Five Estuaries Offshore Windfarm Development Consent Order Application

Planning Inspectorate Reference: EN010115

Text of Summary Relevant Representation from the Royal Society for the Protection of Birds (RSPB)

3 October 2024

Figure 2. Gannet densities in the Northern array (top) and Southern array (bottom). Note different scales on the y-axes.

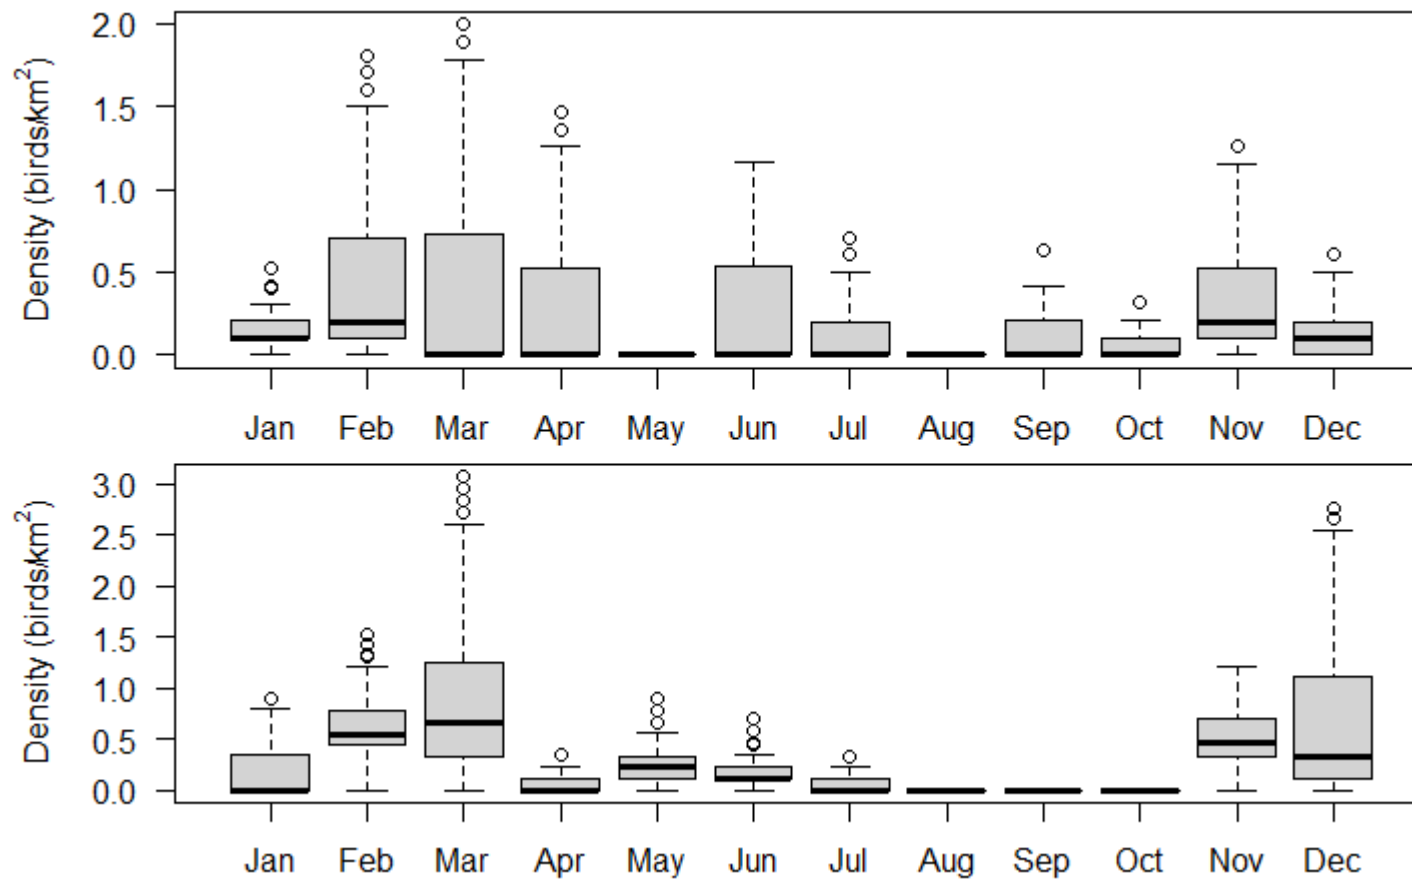
The Applicant has applied a reduction of 70% to the baseline densities inputted into the Northern Gannet collision risk modelling in order to account for macro-avoidance by amending the Avoidance Rates used in Collision Risk Modelling. This approach follows suggestions in Cook (2021).

As Northern Gannets can show macro avoidance it was suggested that this was applied to the baseline densities, and then collision risk modelling was carried out using an 'all gull' avoidance rate, so effectively applying avoidance twice. The RSPB does not agree with the approach. Firstly, it does not consider seasonal variation. Secondly, by basing the 'within wind farm' avoidance rate on the 'all gull' rate, it assumes that Northern Gannets will have the same 'within wind farm' reactive flight response as gulls. This assumption is very unlikely to be met. This will result in a lesser ability to make rapid reactions and consequently have a greater risk of collision. This should be reflected in the 'within wind farm' avoidance rate if any further changes are to be made.
